# MetroLink - Module 1

LTR DATED  
LDG-  
Charlemont & Dartmouth Community Group  
(Paul Quigley) Presenter

## Witness Statement by Paul Quigley on Behalf of Charlemont & Dartmouth Community Group in relation to Soils and Hydrogeology

Figure 4-2: Settlement Assessment Flowchart With Building Categorisation Detail (Preliminary Design Phase in Blue)

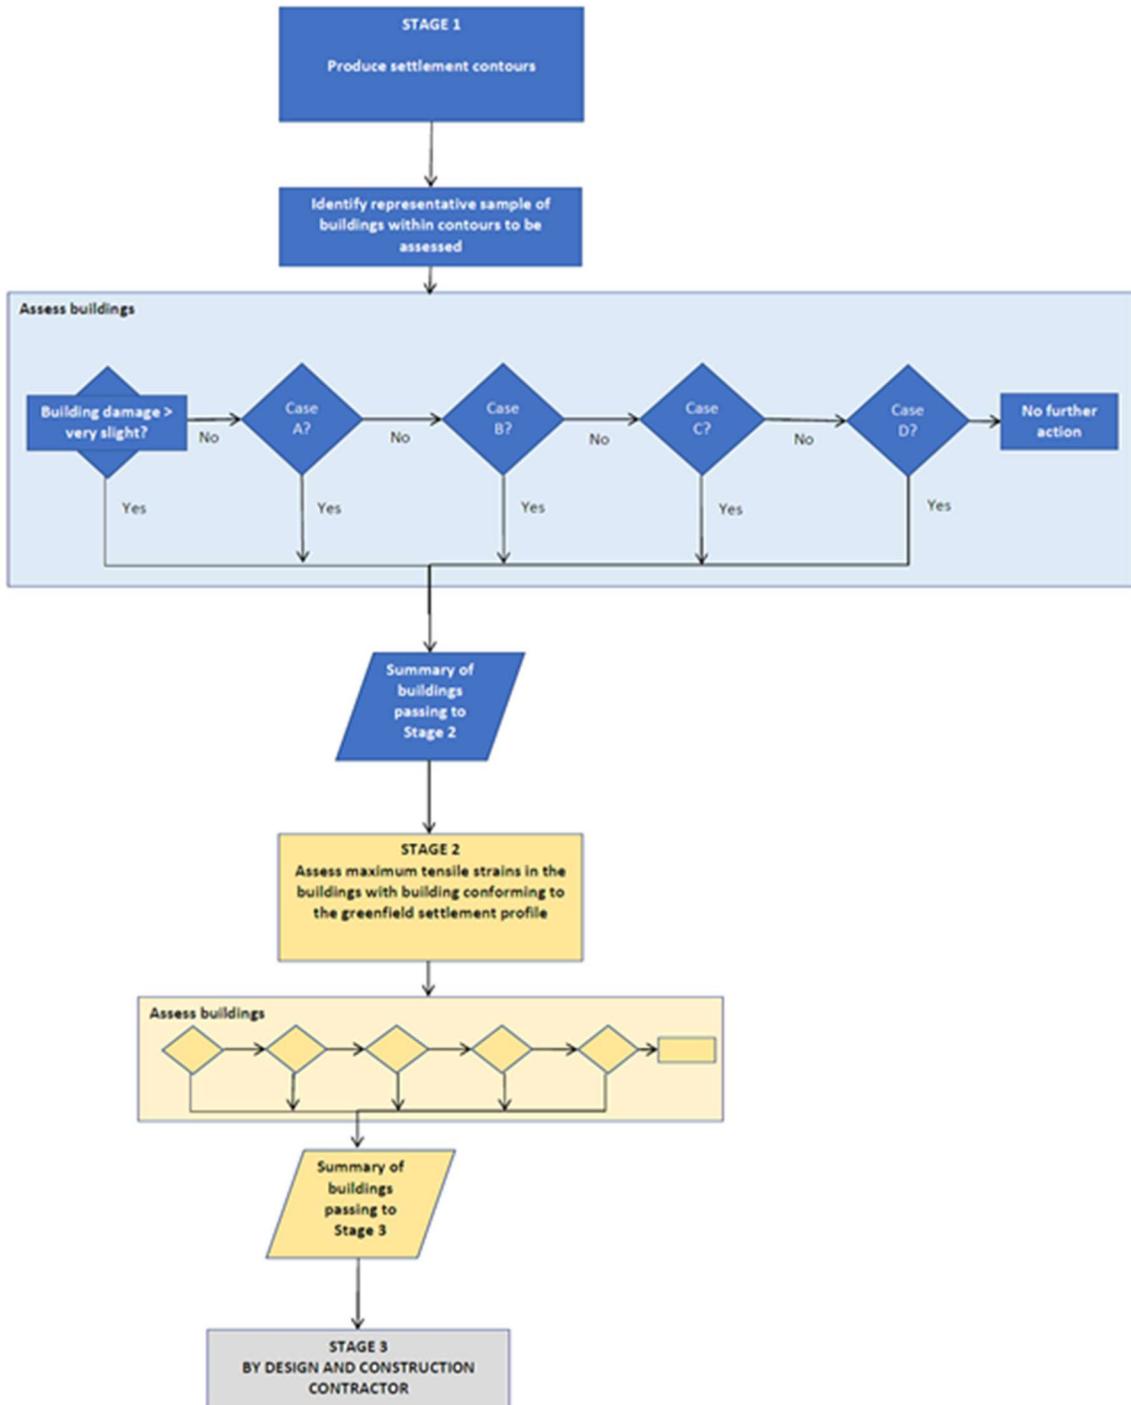
There are workflow processes shown in Figure 4.2 of A5.17, which appear to screen out any intervention. The Stage 2 process seems to be incomplete or incorrect. We note that TII has used a similar screening process developed for the design and planning stage for tunnelling projects such as Crossrail and High Speed 2 in the UK. However, there are no requirements to limit the planning process to this screening process.

Drawing No.	ML1-JAI-EIA-ROUT_XX-DR-Y-21149	Rev	P02
-------------	--------------------------------	-----	-----

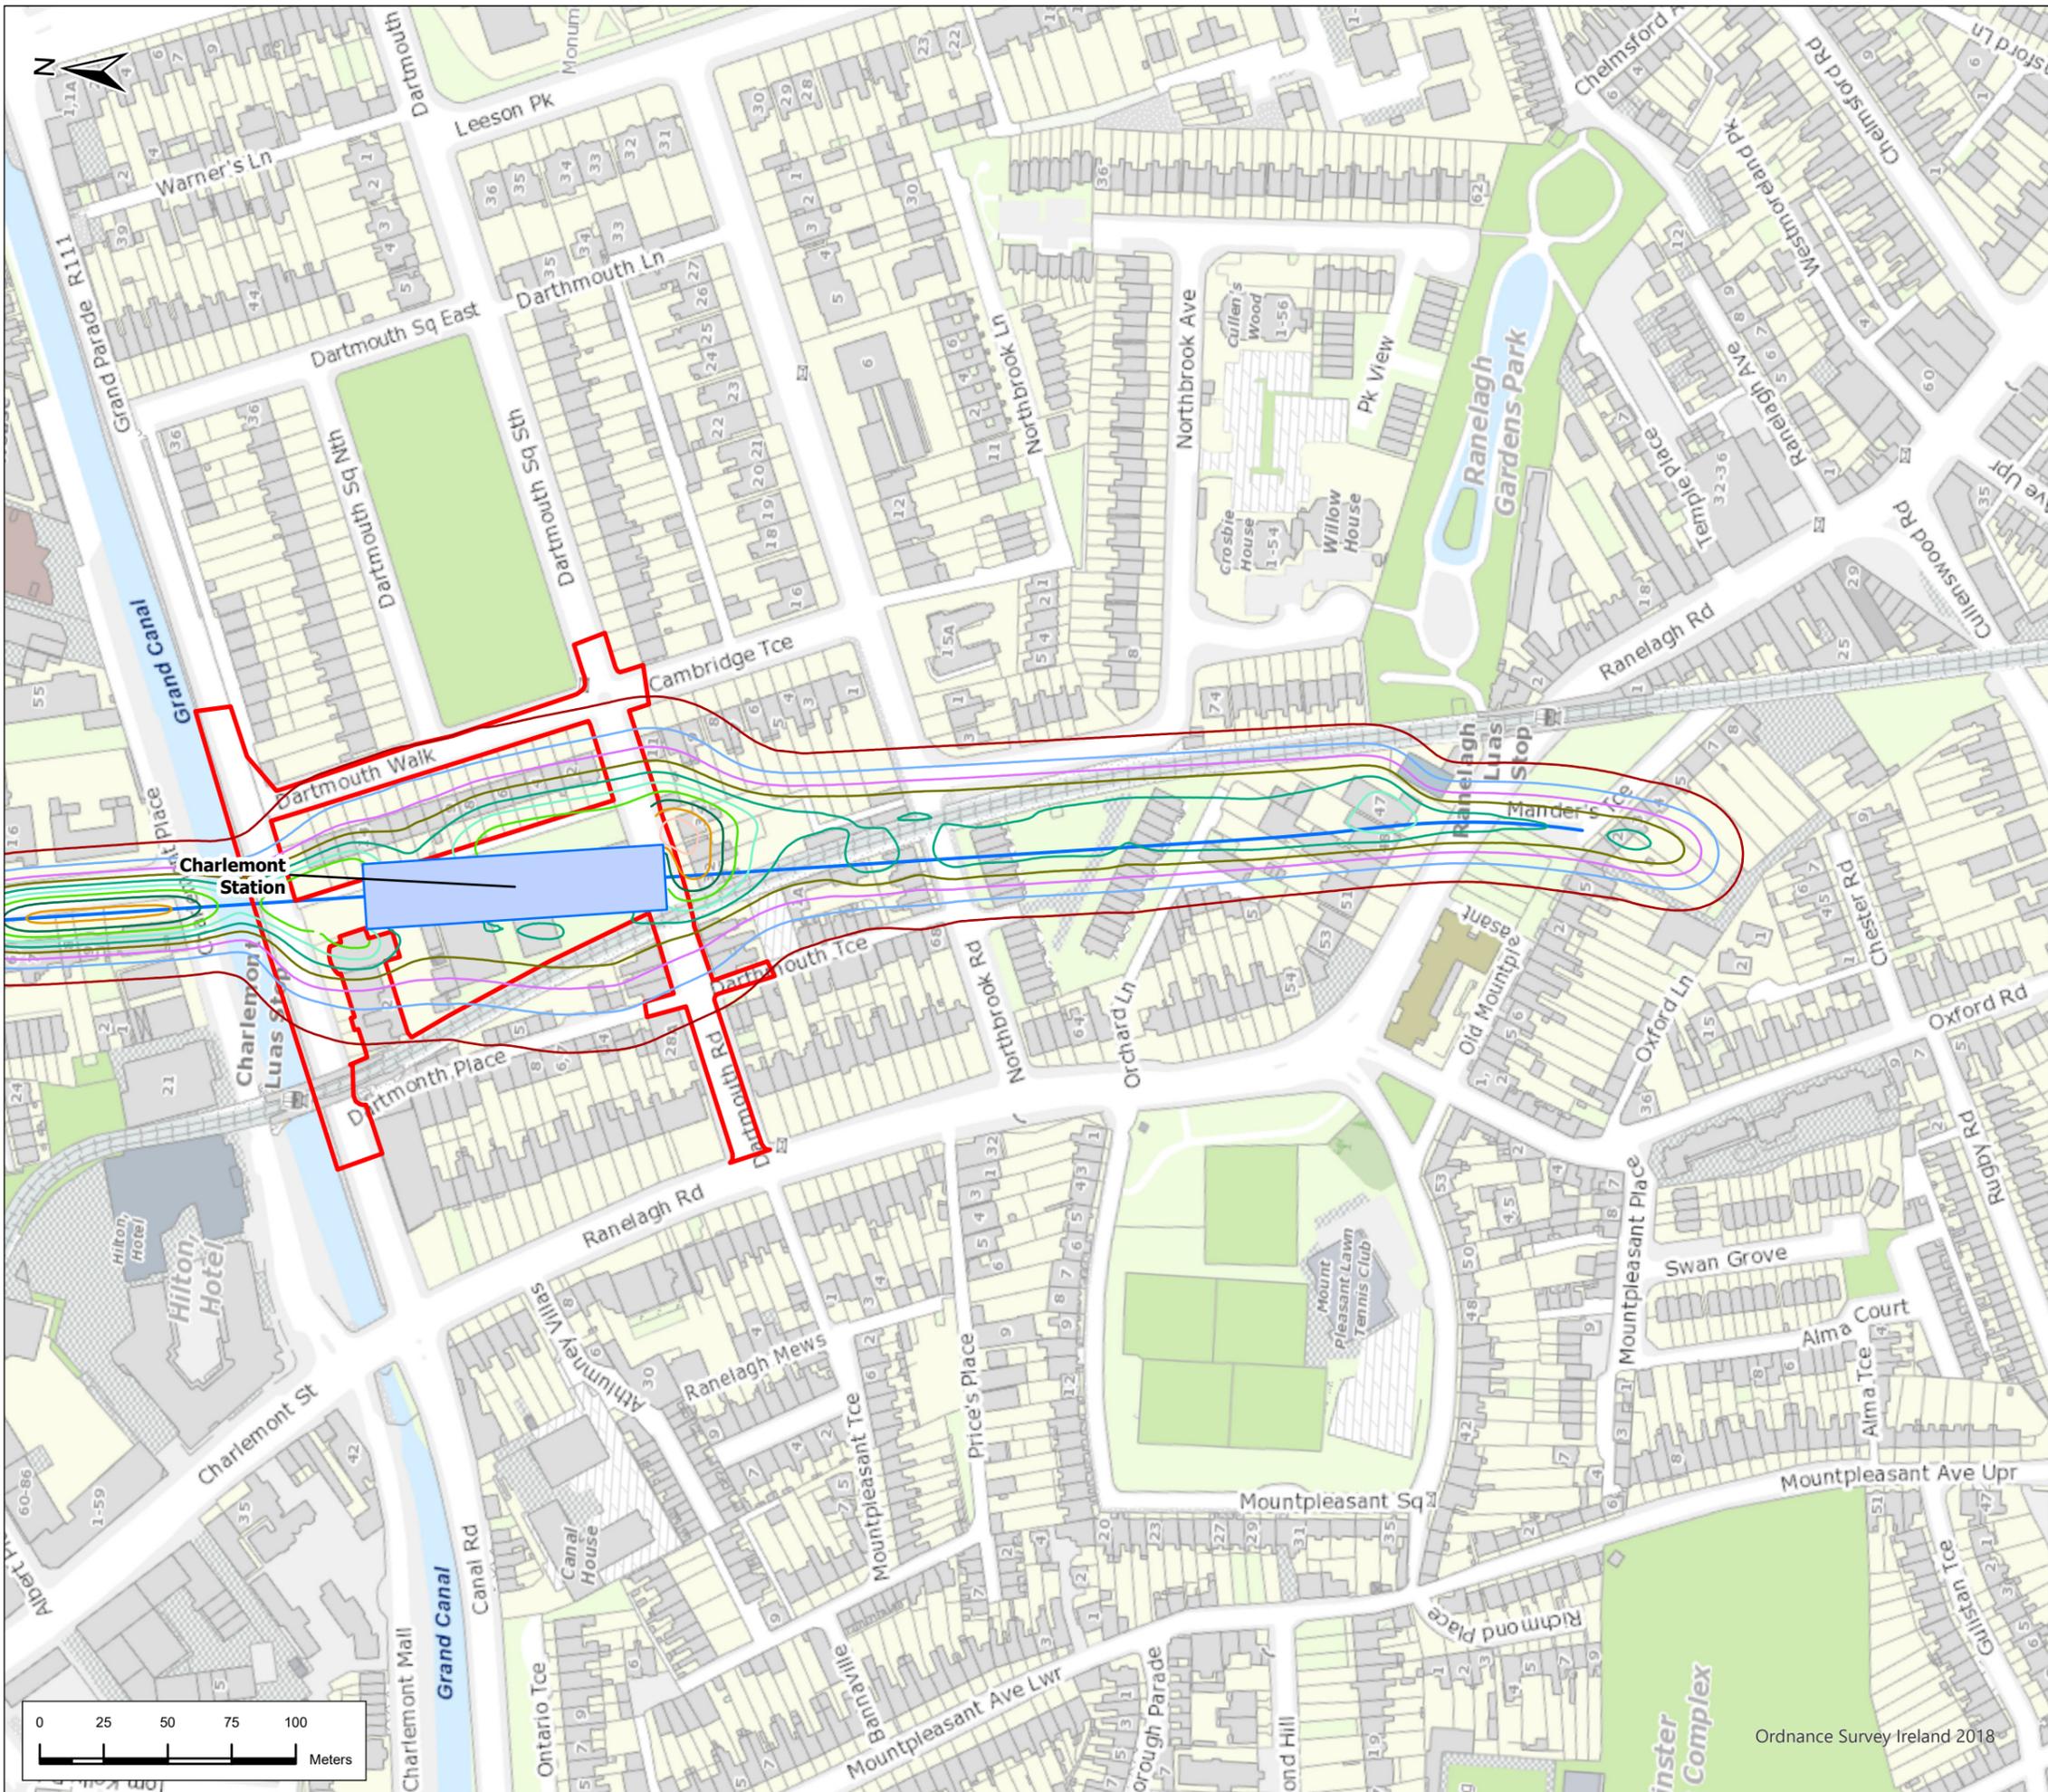
There are some concerning drawing conflict and quality issues associated with the Building Damage Assessment report. For example, the outline of the basement construction for Charlemont station has been simplified as a rectangle in ML1-JAI-EIA-ROUT\_XX-DR-Y-21150, whereas the extent of the retaining wall shown on the plan drawing ML1-JAI-SRD-ROUT\_XX-DR-Y-0209 and cross section drawing ML1-JAI-SRD-ROUT\_XX-DR-Y-02097 appears more realistic. The impact of the ground movement contours along Dartmouth Square West could significantly change the damage impact rating.
